Freedom Forever
Planset Revision Letter

12/30/2023
REV #1

Attn. Harnett County (NC):

JESUS GONZALEZ
11 VISTAS COURT, LILLINGTON, NC 27546

THREE LINE DIAGRAM			
JOB NO: 354438	DATE: 1/22/2024	DESIGNED BY: A.W.	SHEET: PV-4

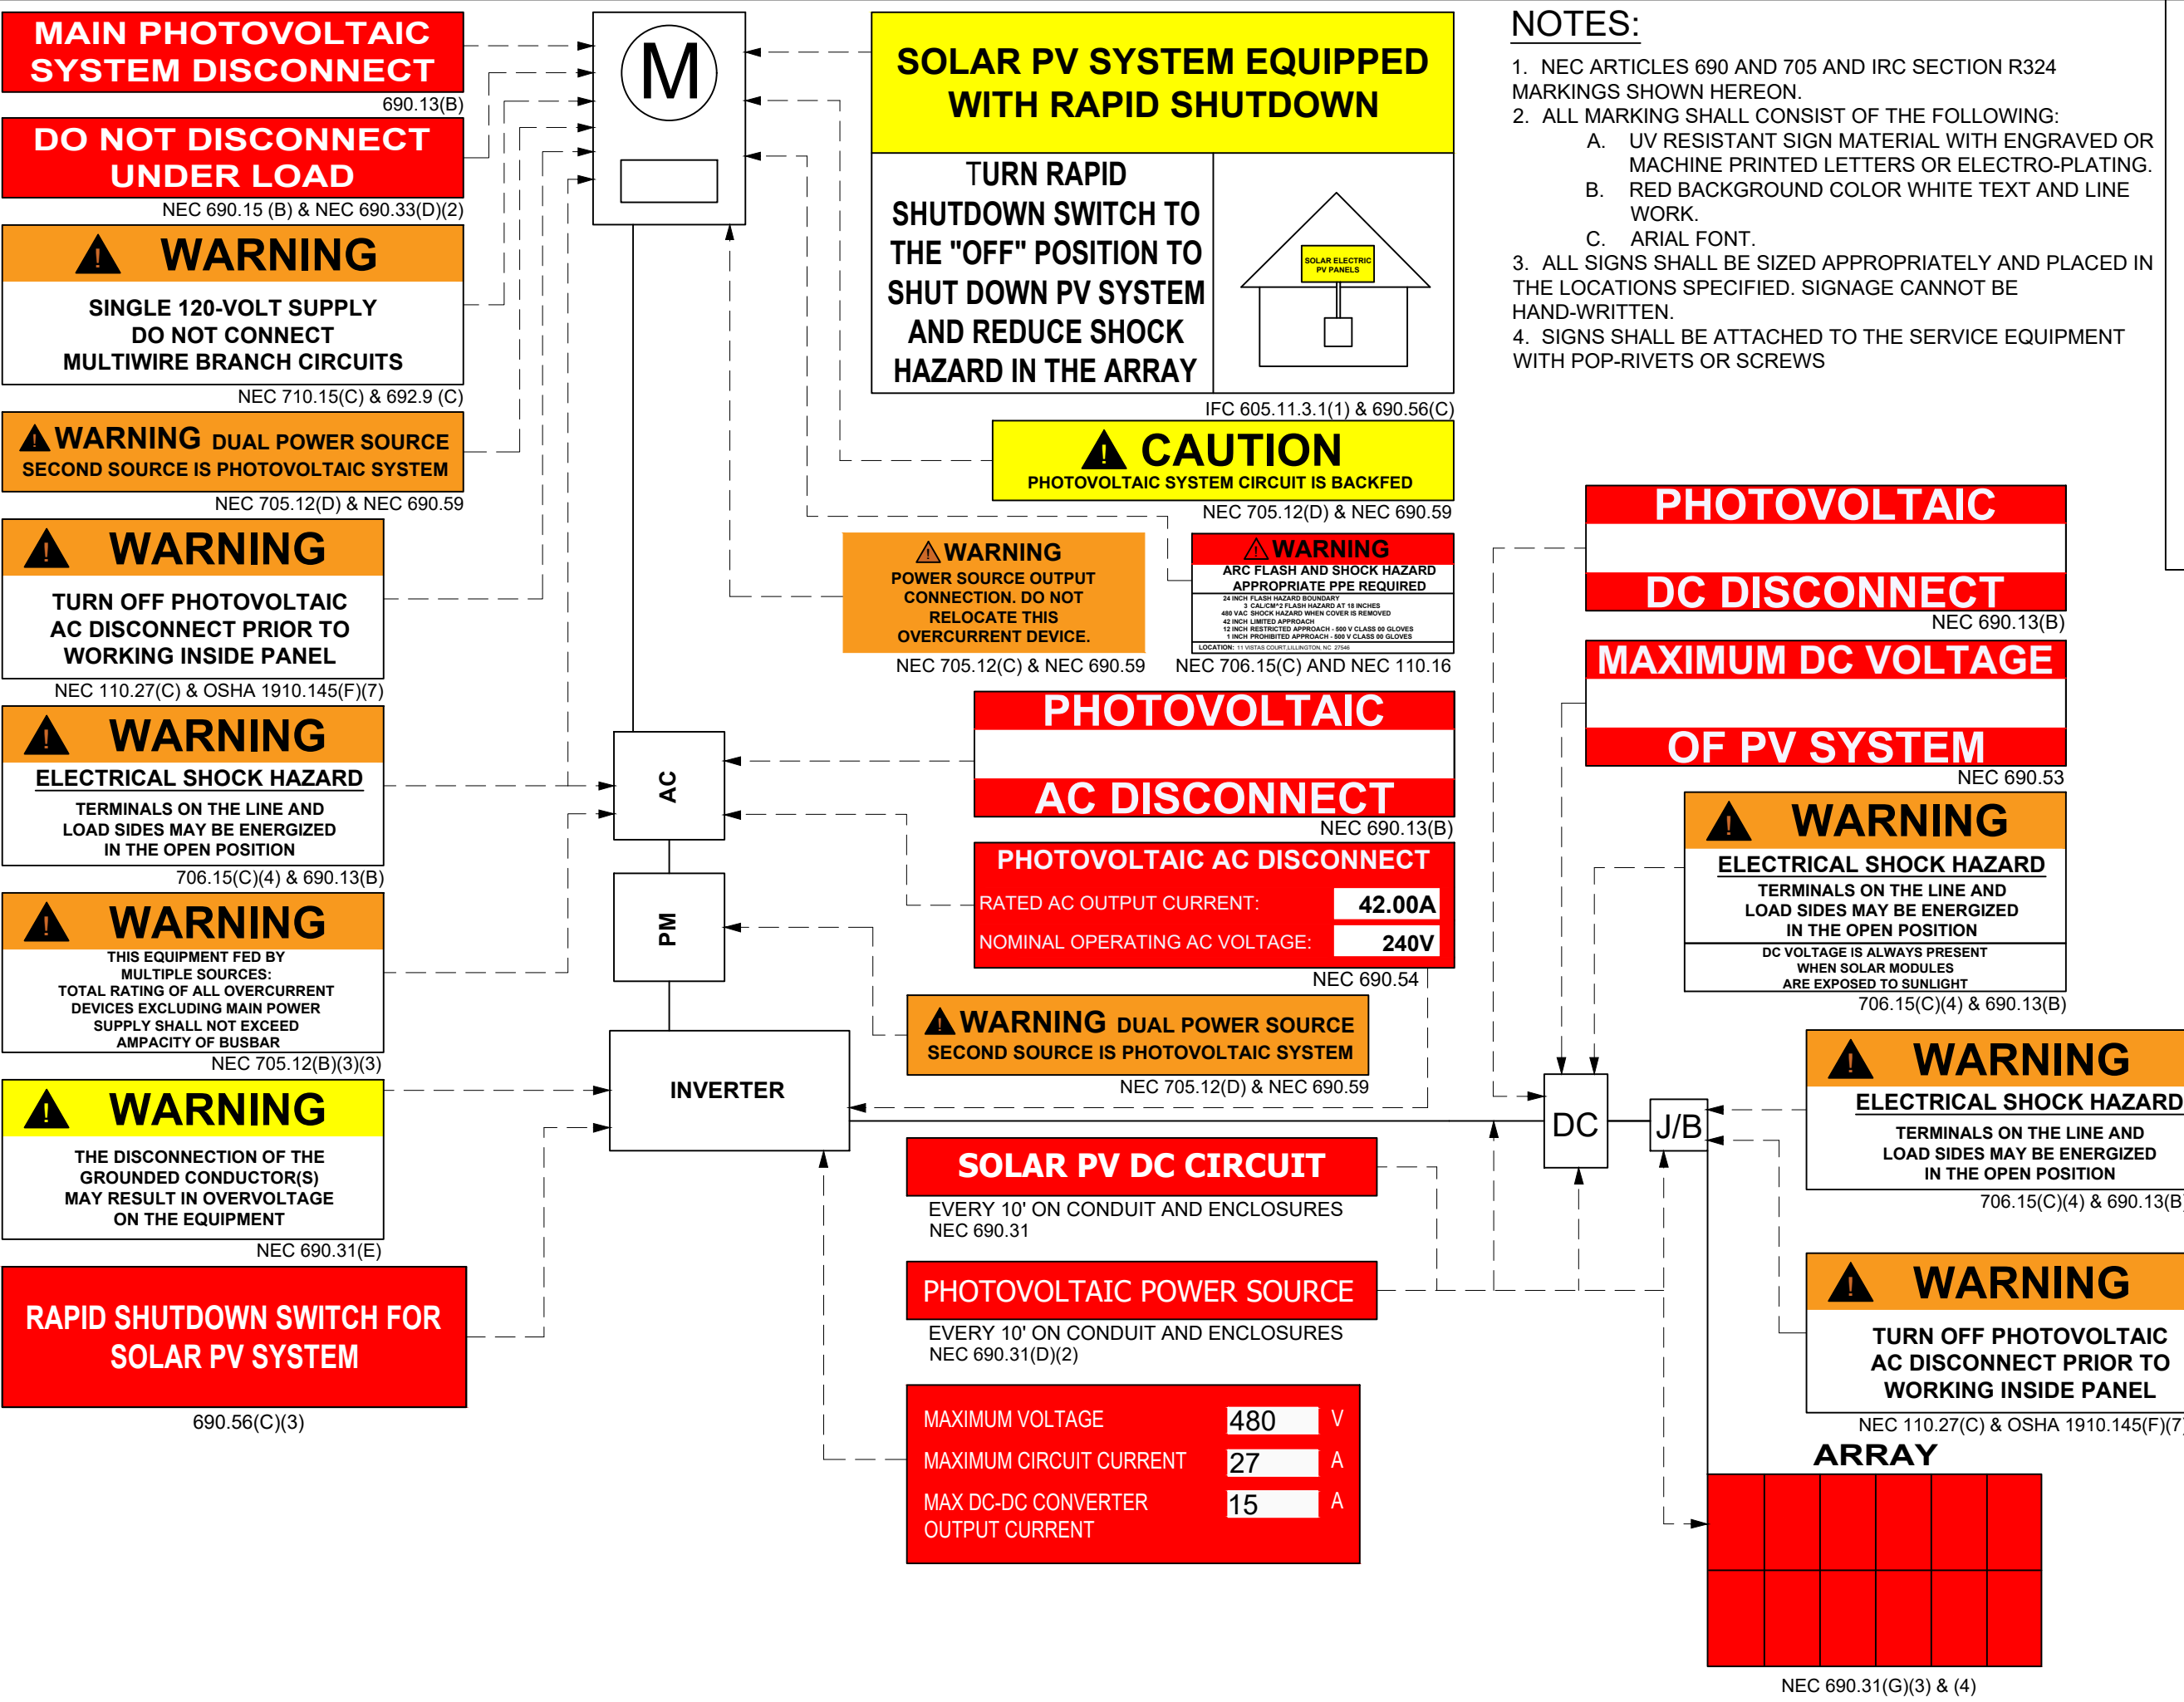
1. MSP corrected to 200A (hot bus) - page PV-4
